Our Ref: 2026/036276

Council Comments on Response to Submissions - SSD-91496958 - 159-167 Darley Street West, Mona Vale

APPENDIX 1 - DETAILED COMMENTS FOR ADVICE ON EIS FOR SSD-91496958 NORTHERN BEACHES COUNCIL

APPENDIX: A.1 LOWER GROUND FLOOR PLAN

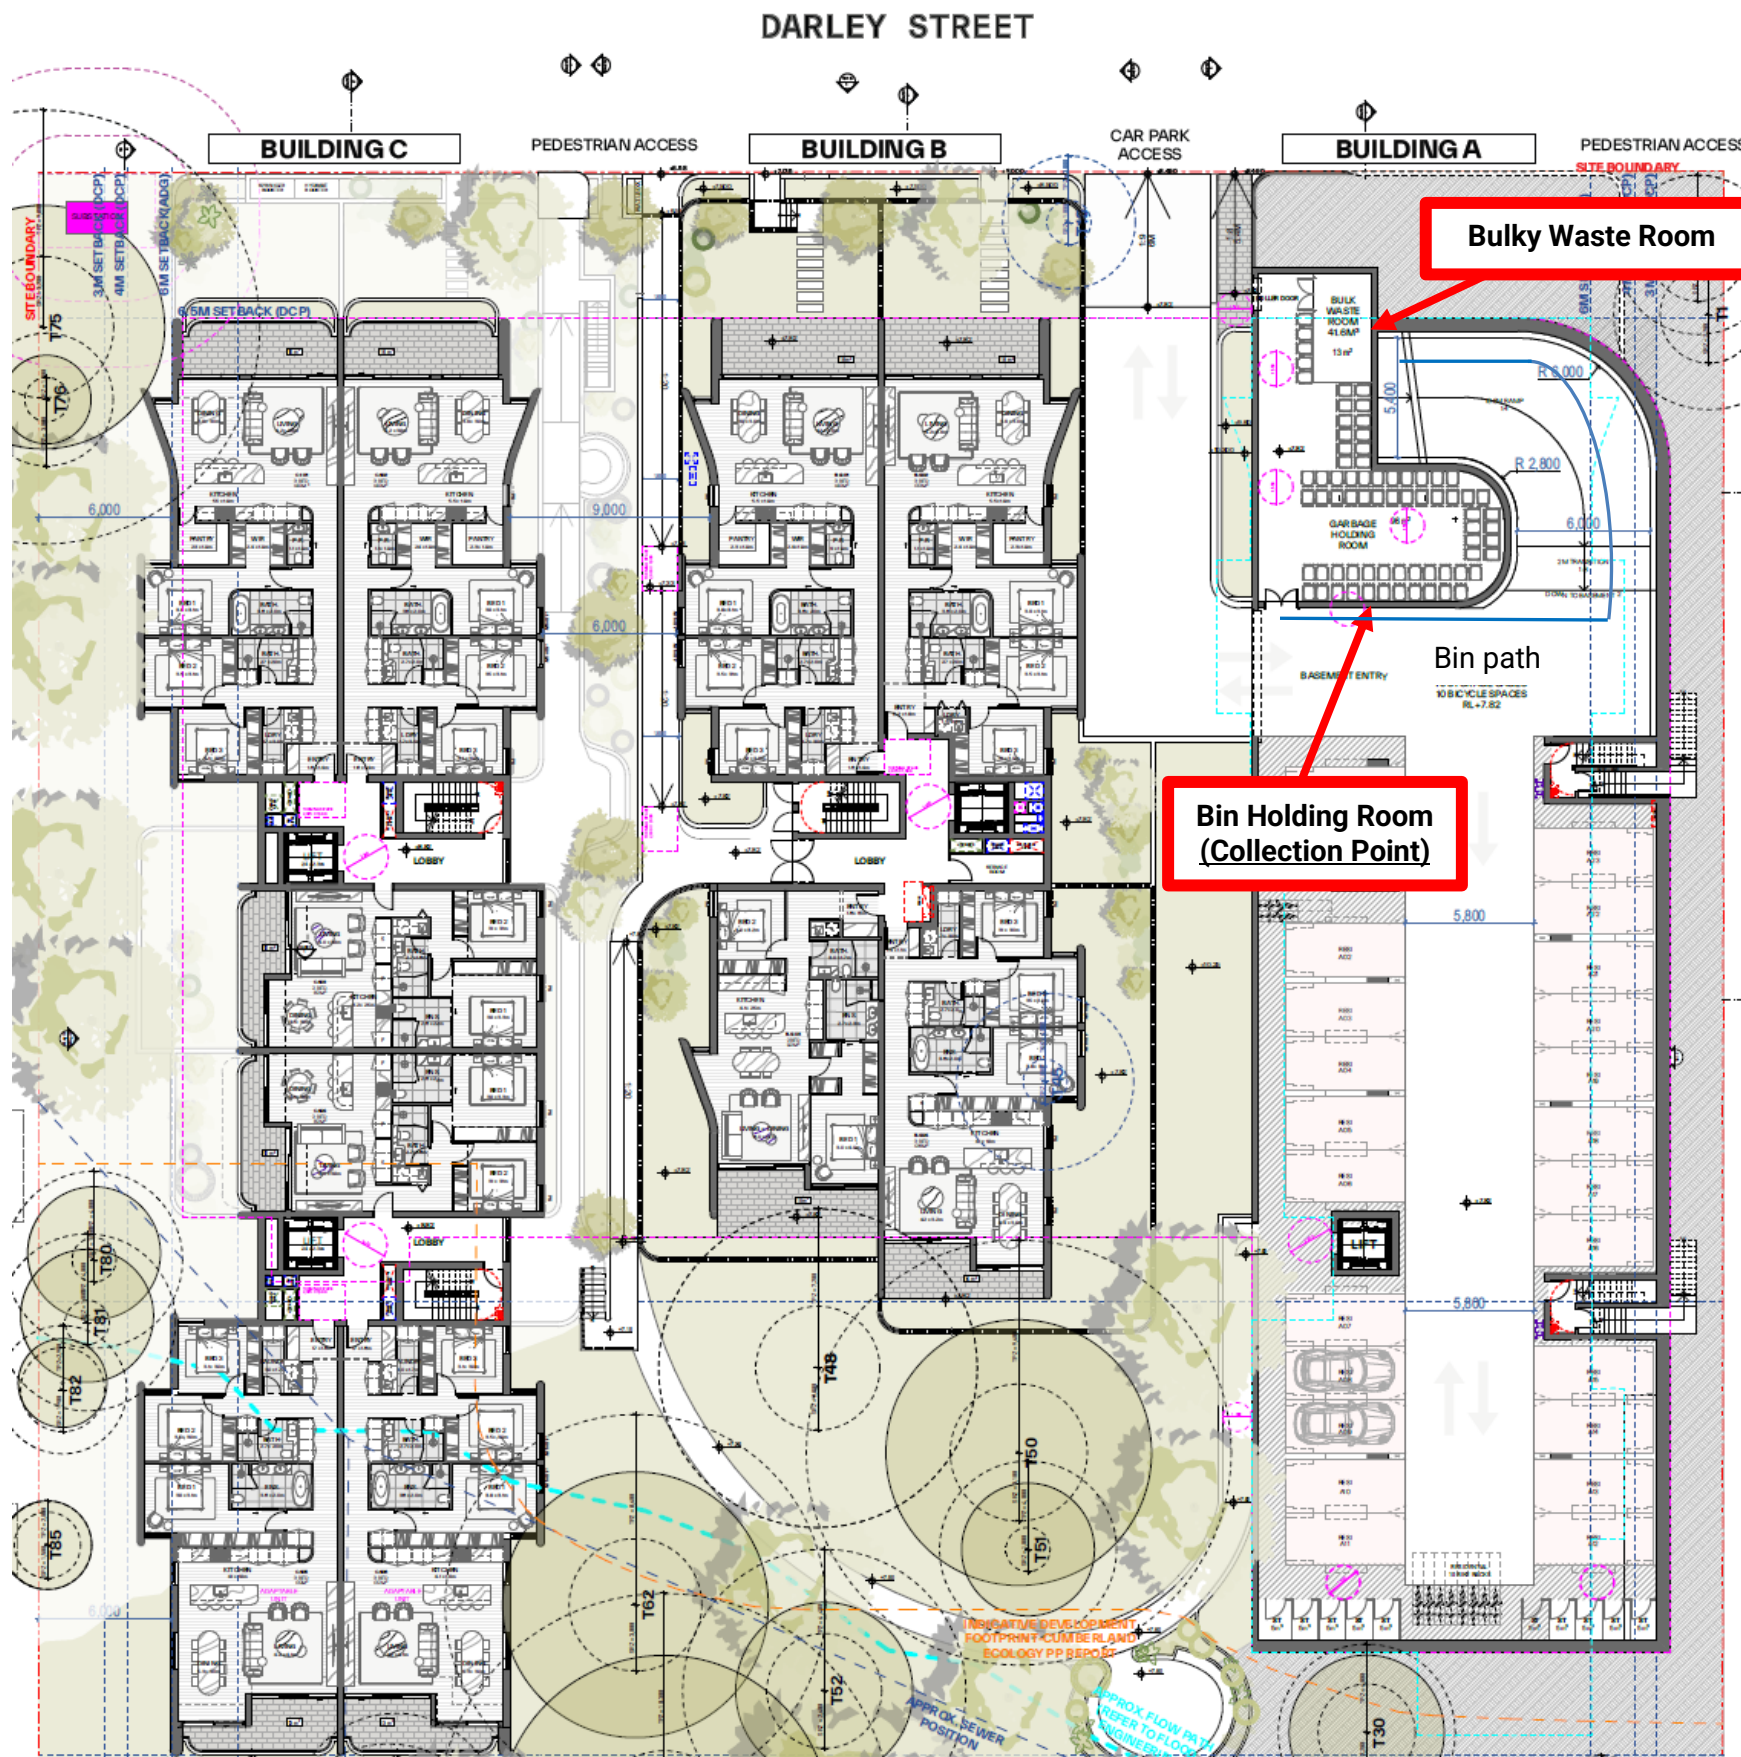
Chutes discharge into four basement waste storage rooms with chutes, and a bulky waste storage room can be identified in the basement of the building on the architectural plans. Plans should be updated to show actual 660L bins in chute room and that there is sufficient room for a linear track and for manoeuvring of bins. Bin and track dimensions should be shown.

The individual chute rooms for each core are acceptable provided doors are of sufficient width. Each chute room will house a 2-bin linear track 660L chute discharge system with a spare service bin. Compaction is not permitted due to damage caused to bins. Residents must not have access to the chute discharge rooms at any time. The Building Manager will be responsible for managing the chute and their bins.

1 RAMP TO BASEMENT 3 1:100

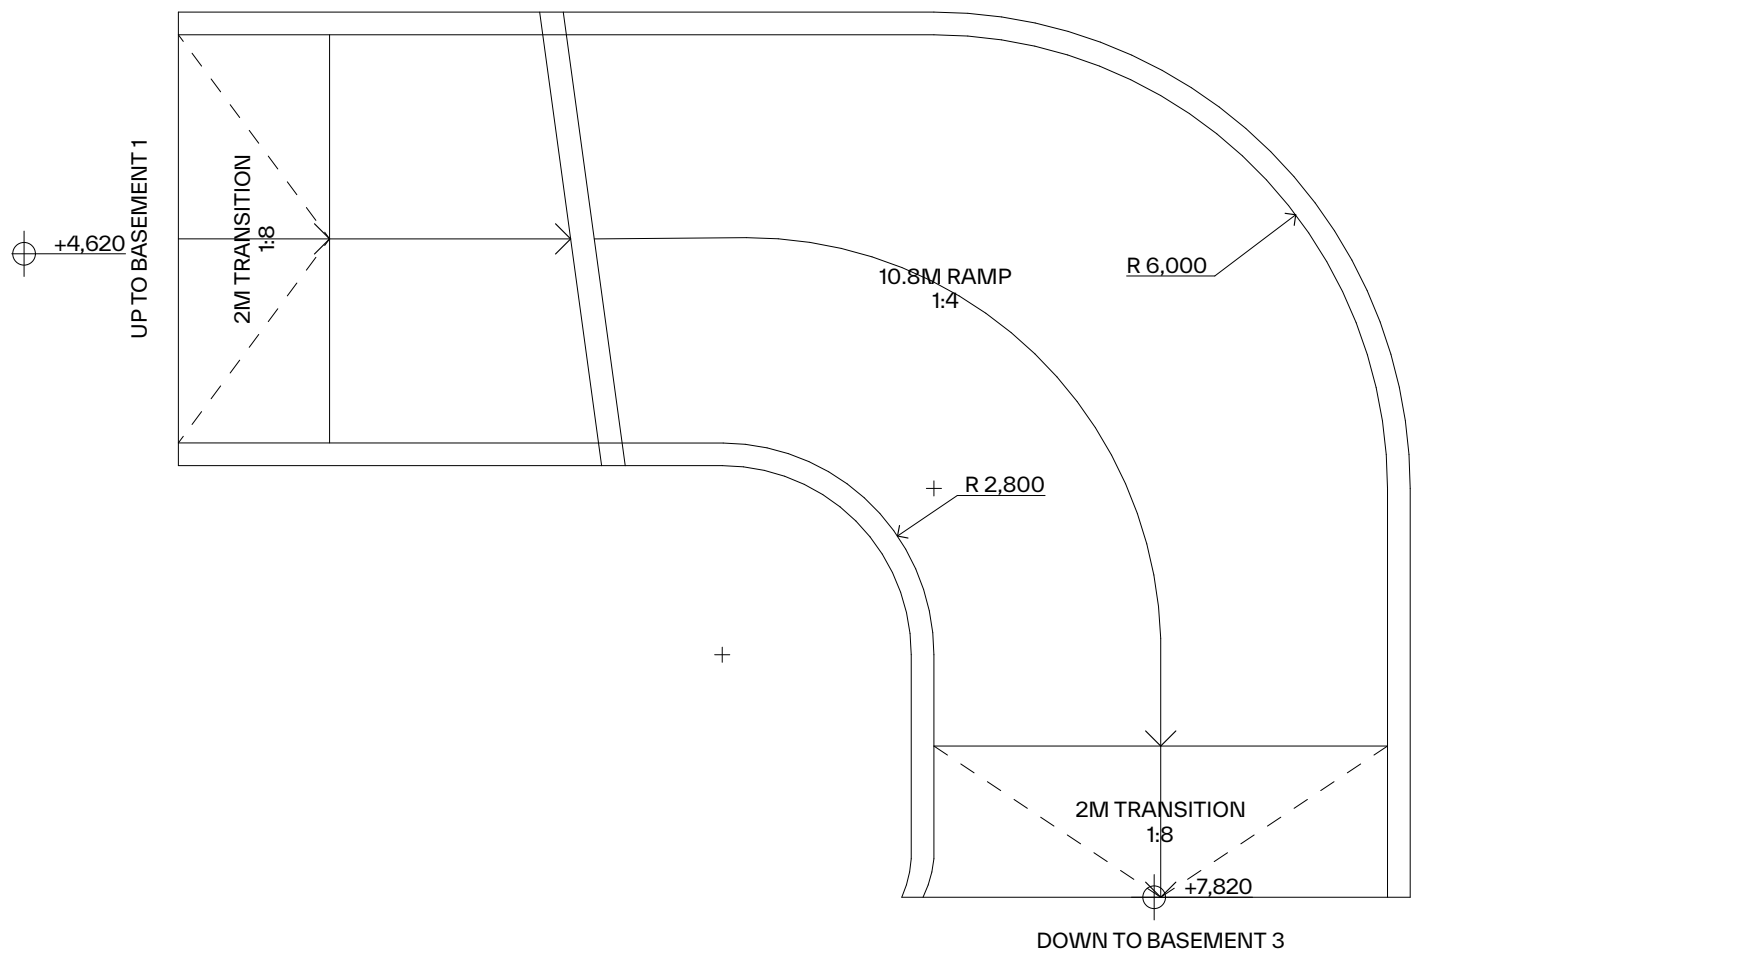
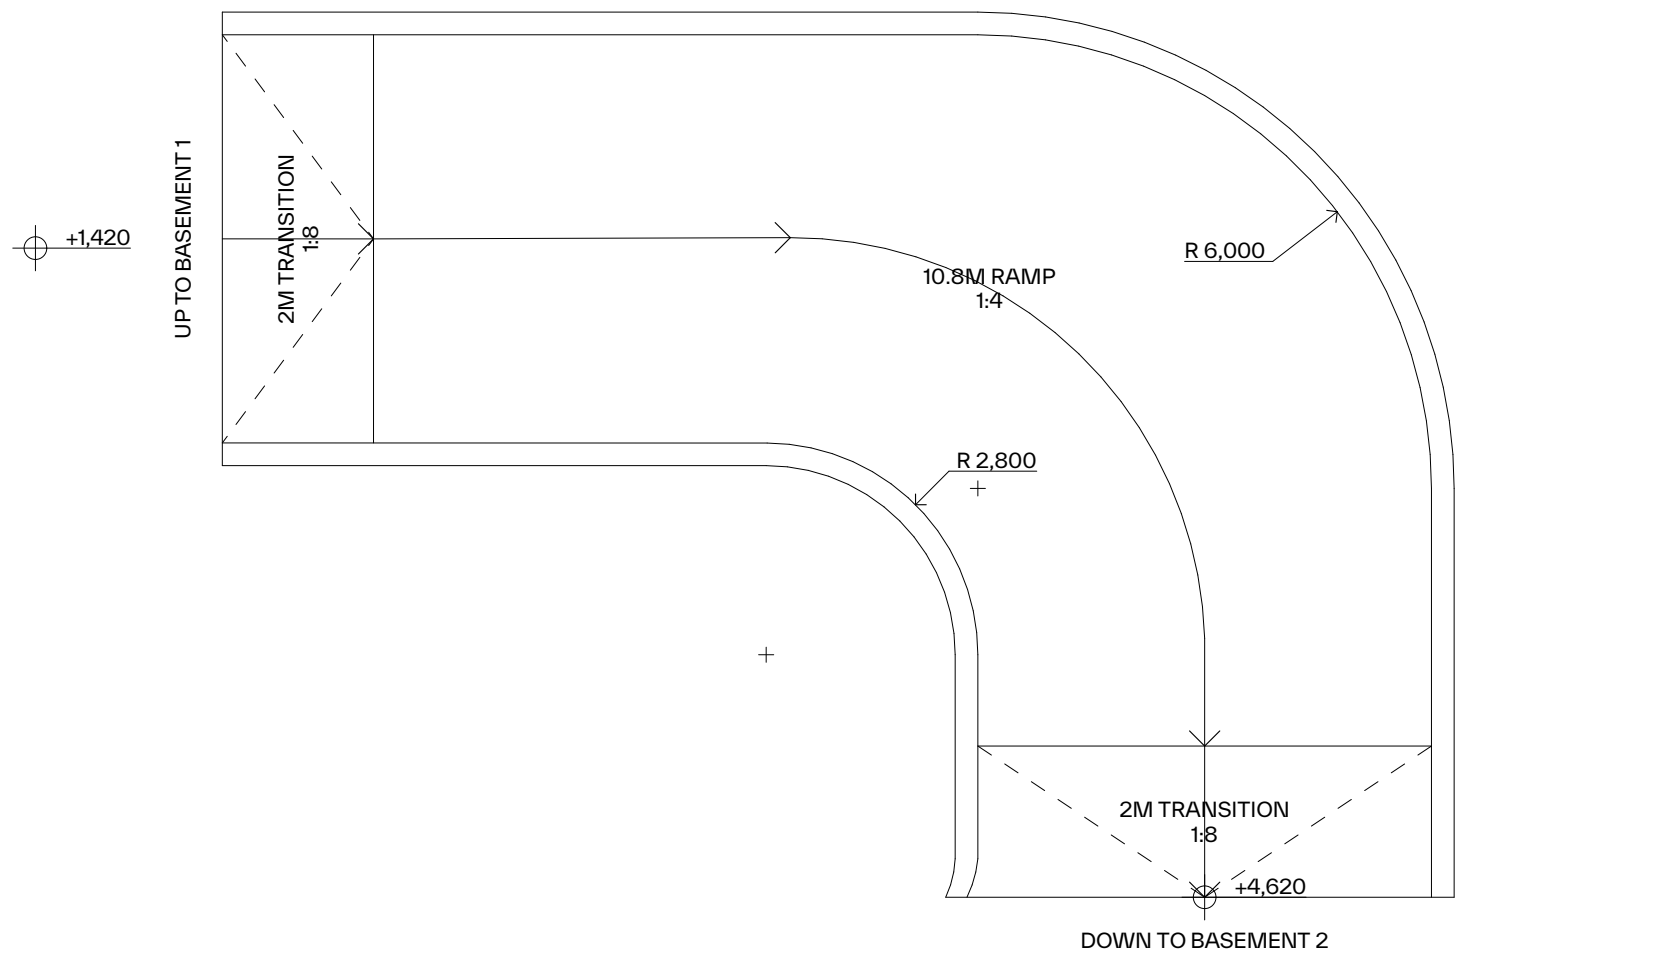
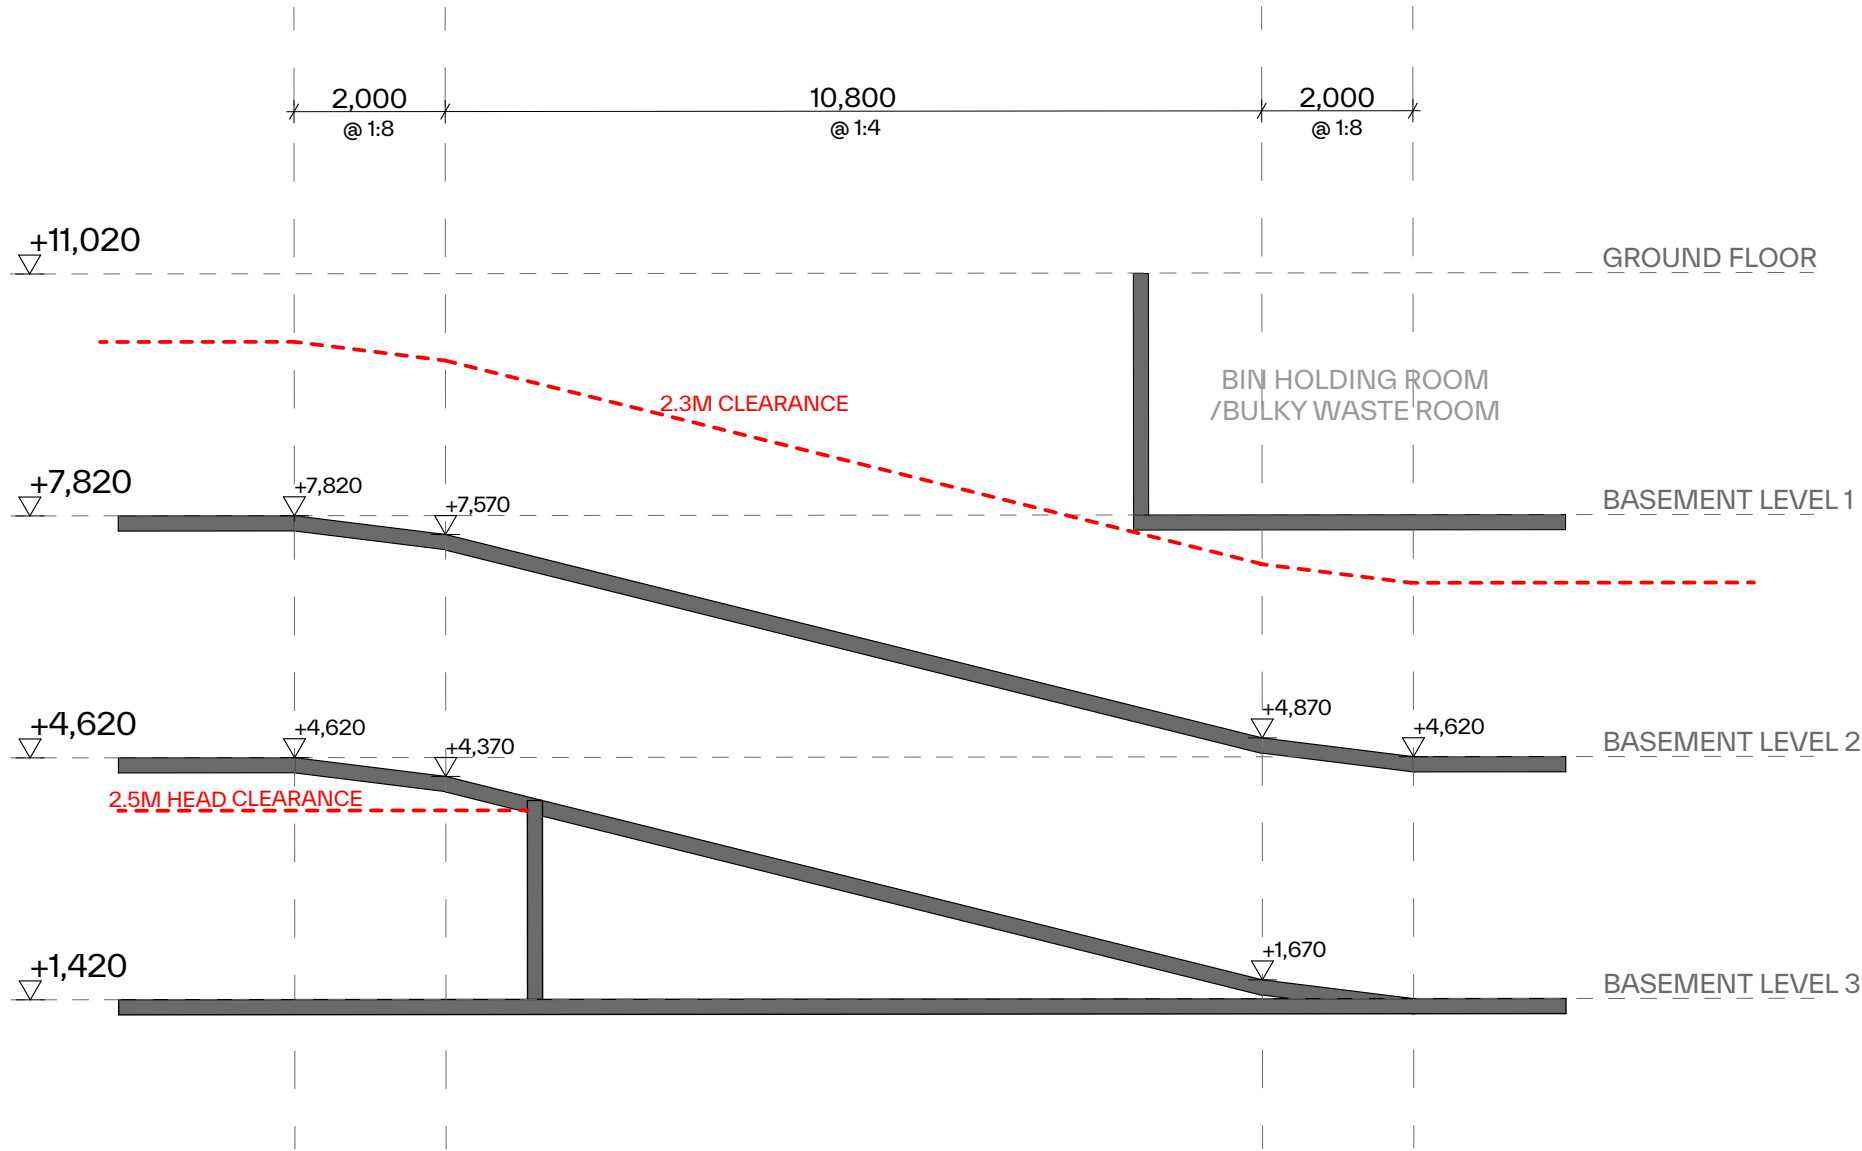
The access road should be designed for the largest vehicle that would access the subject site, noting the waste collection vehicle is 10.5m and the development is likely to be serviced by this size vehicle, circulation should be provided to address the HRV design vehicle.

Vehicle circulation throughout the carpark must be demonstrated for a B85 vehicle passing a B99 vehicle. With all critically located parking spaces demonstrated to provide acceptable access for a B85 vehicle.
